From: Zac Denton
Sent: 08 March 2019 12:00
To: Karen Parsons
Cc: Nicola Spencer
Subject: FW: A/3/19/L - Weavers, High Street

AMENDMENTS
A March 2019 Further information added for shower screen.

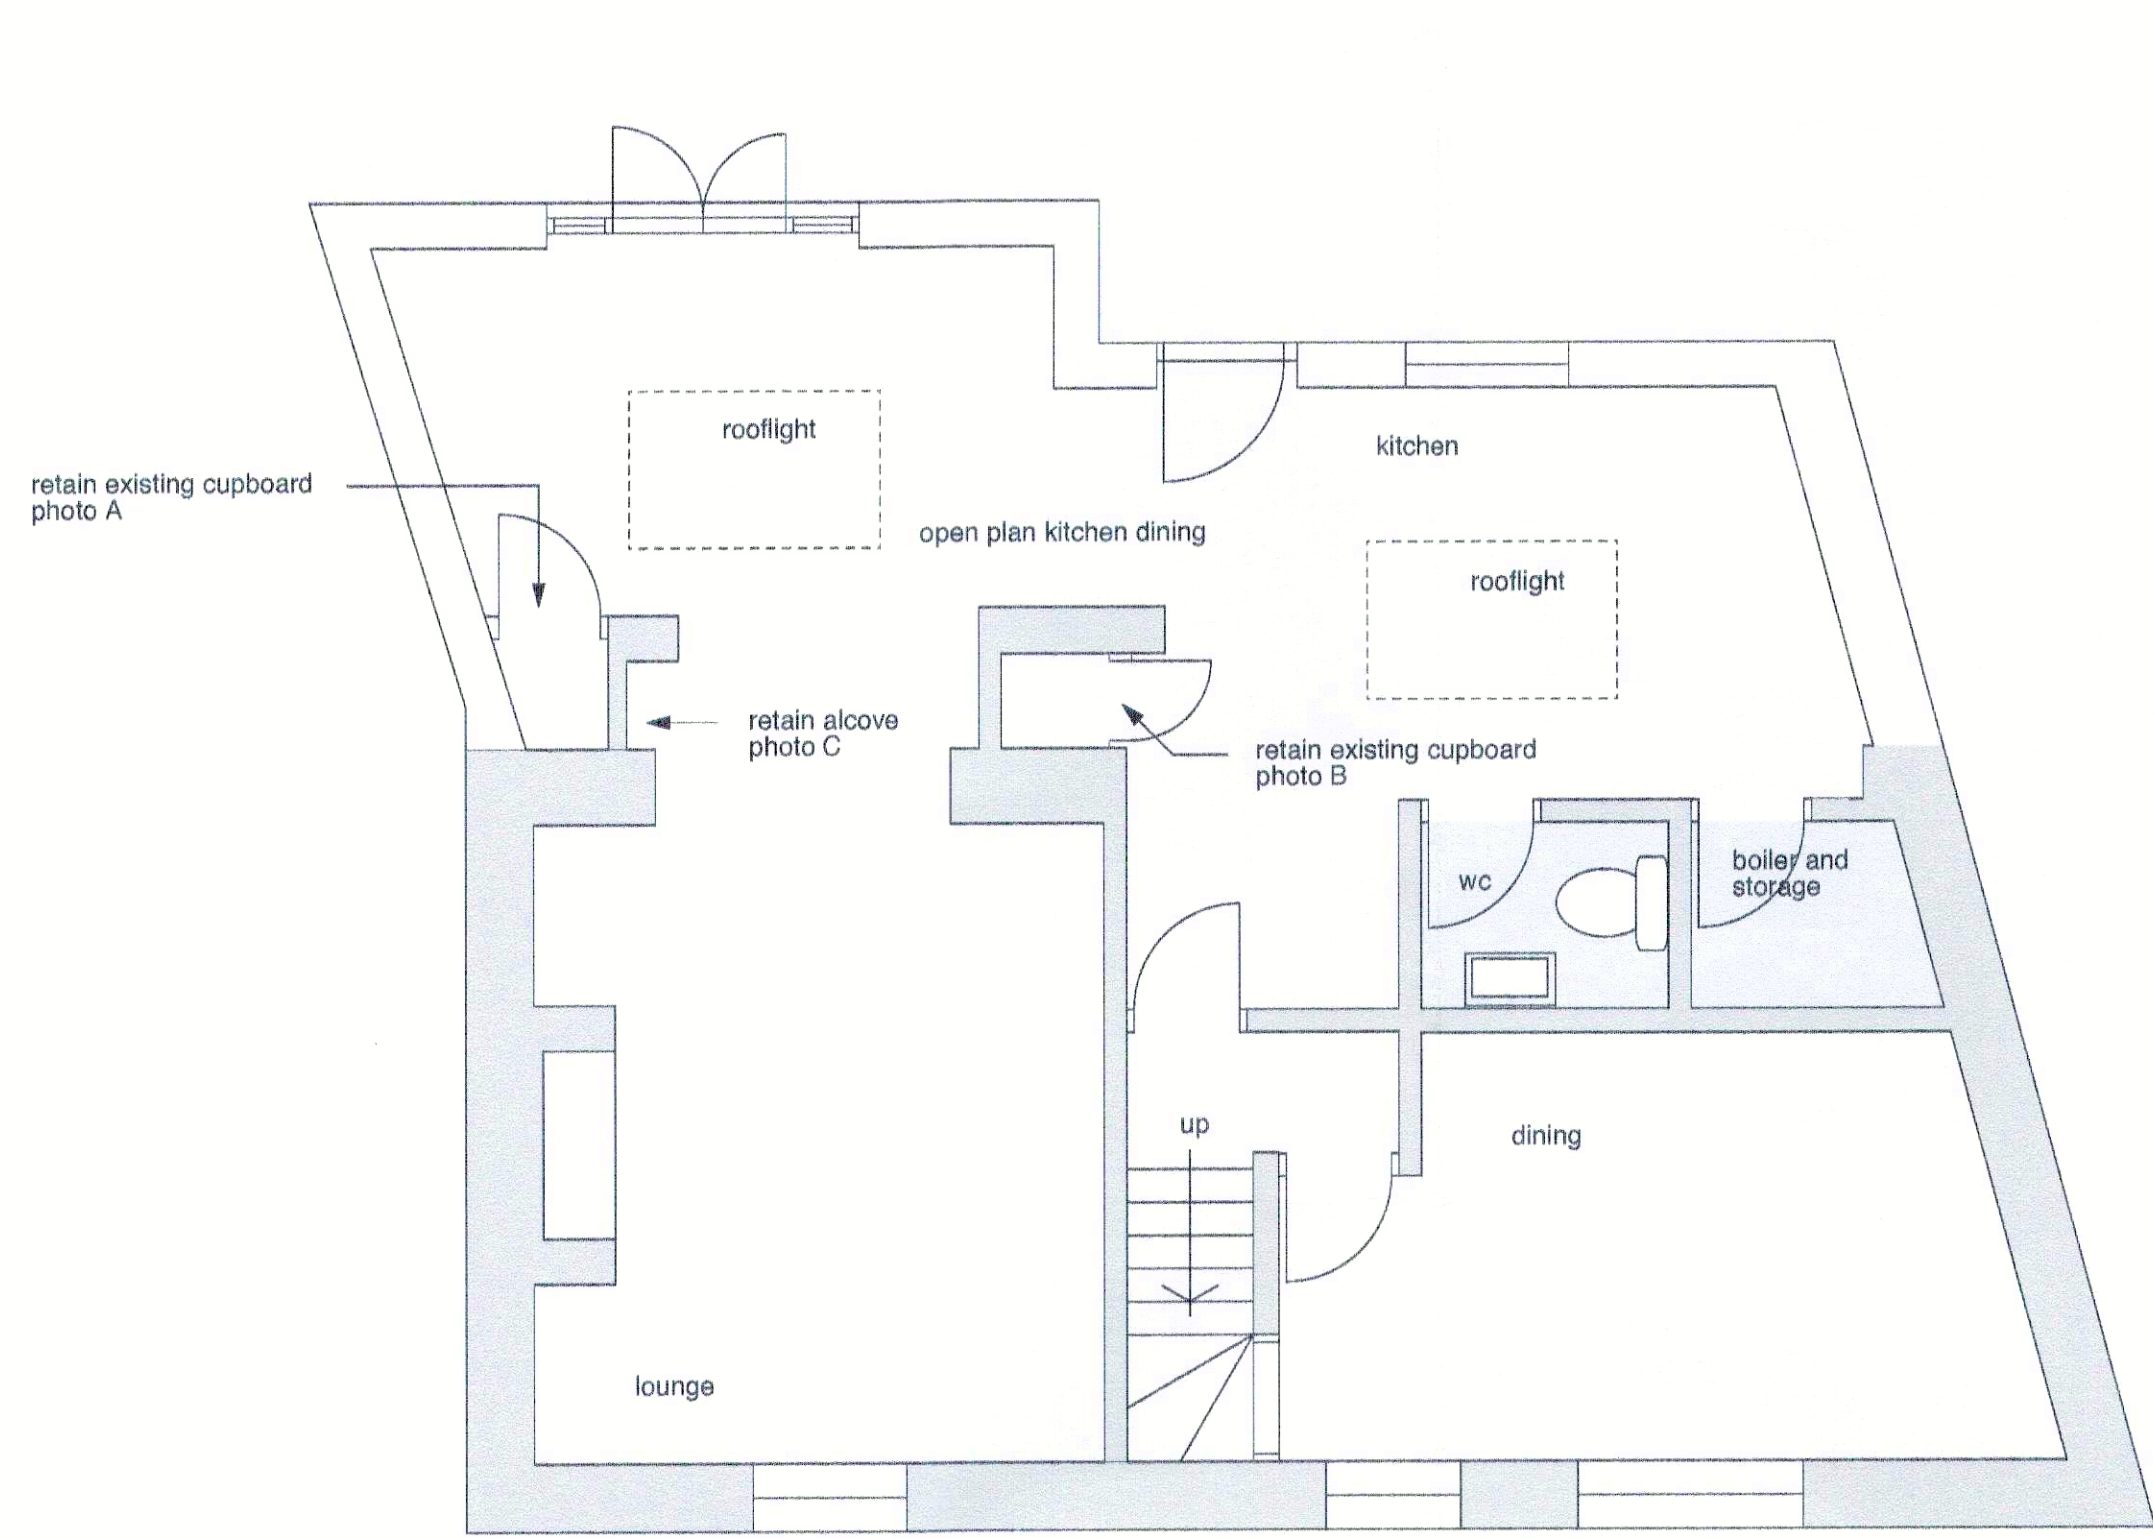
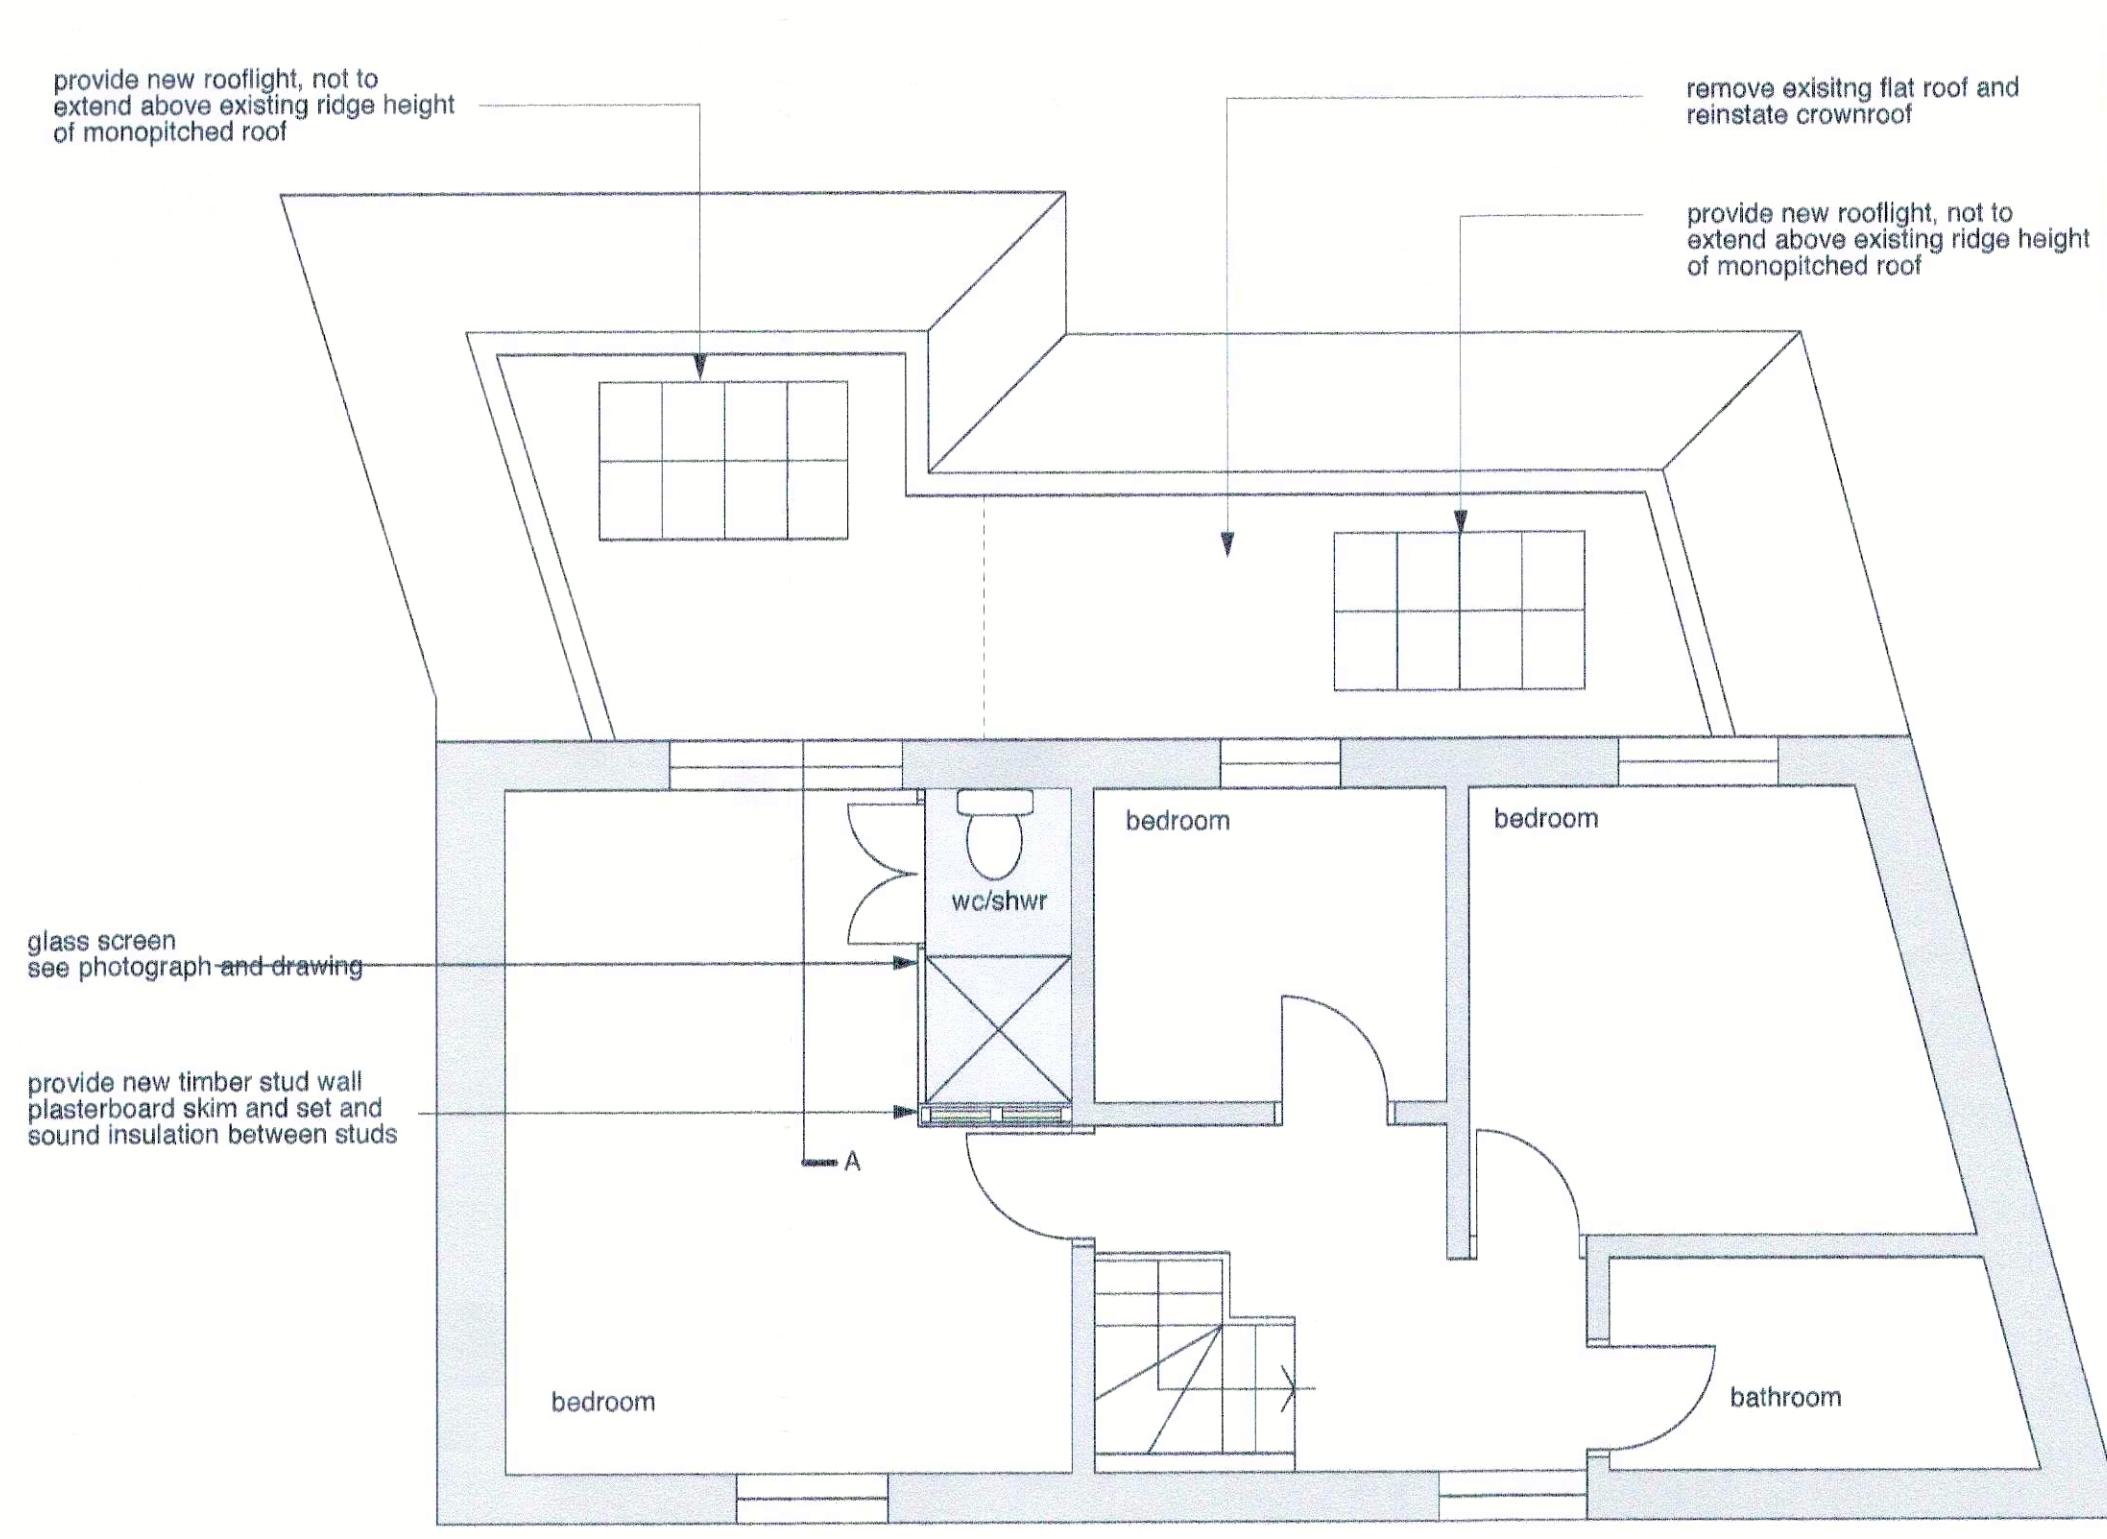
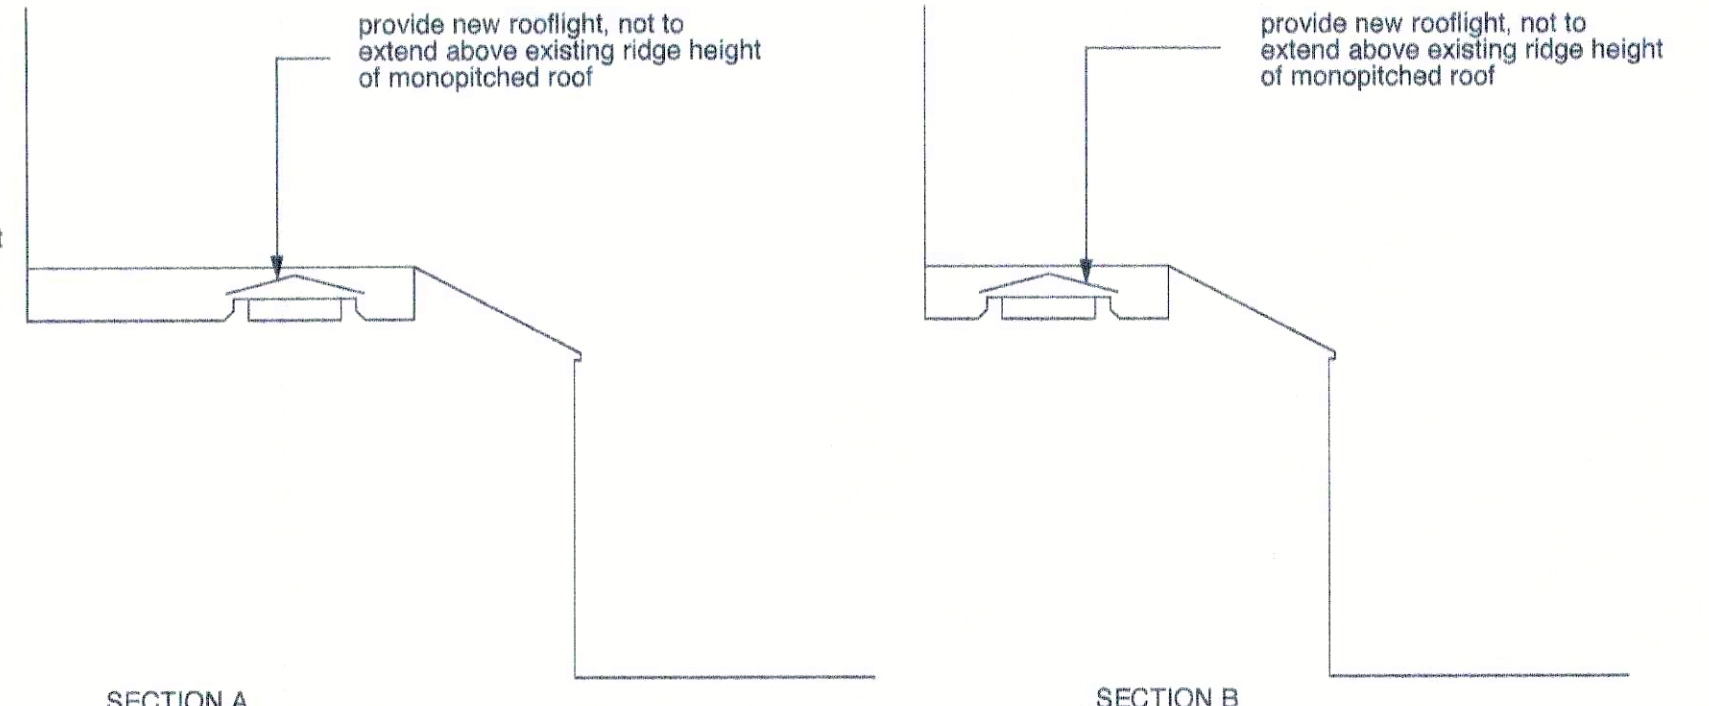
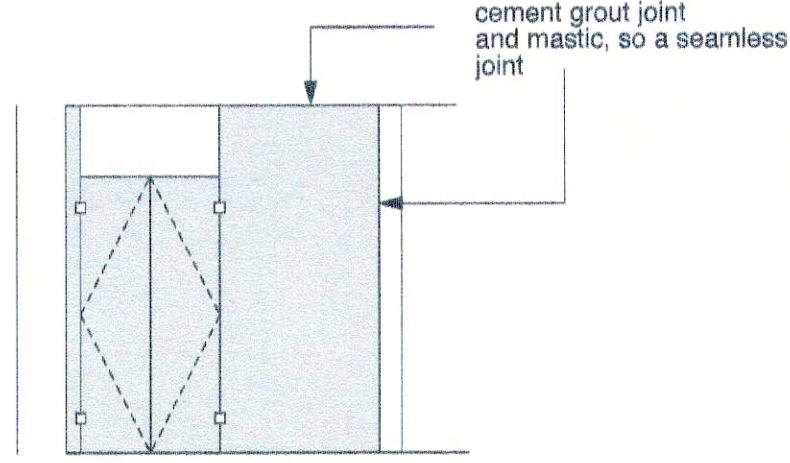
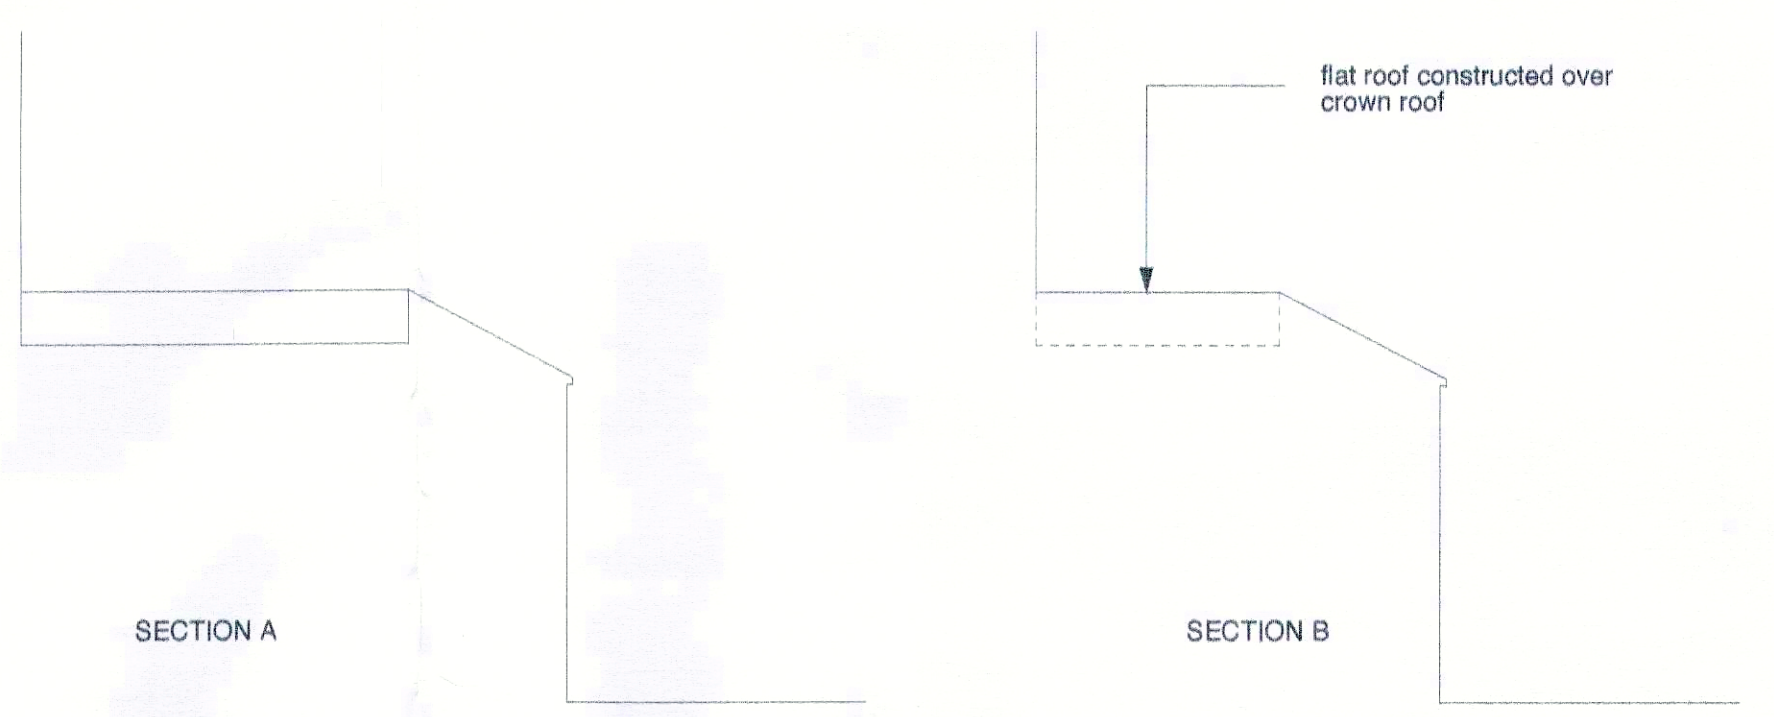
Do you have any further information? Relating to its physical appearance, size etc.?

Regarding the above application, do you have any details relating to the glass screen, proposed in the bathroom of the development? *E.g is it fully frames, glazed, what colour is it etc.*

I have provided further information on the glass screen and have put these on a drawing which has been posted to you today.

As can be seen the connections will be seamless so there will be very little disturbance of the original fabric and there are no demolition works except the removal of a wardrobe which of course is not original.

Yes the glazed panels will fit within a s/w timber frame which will be painted white.
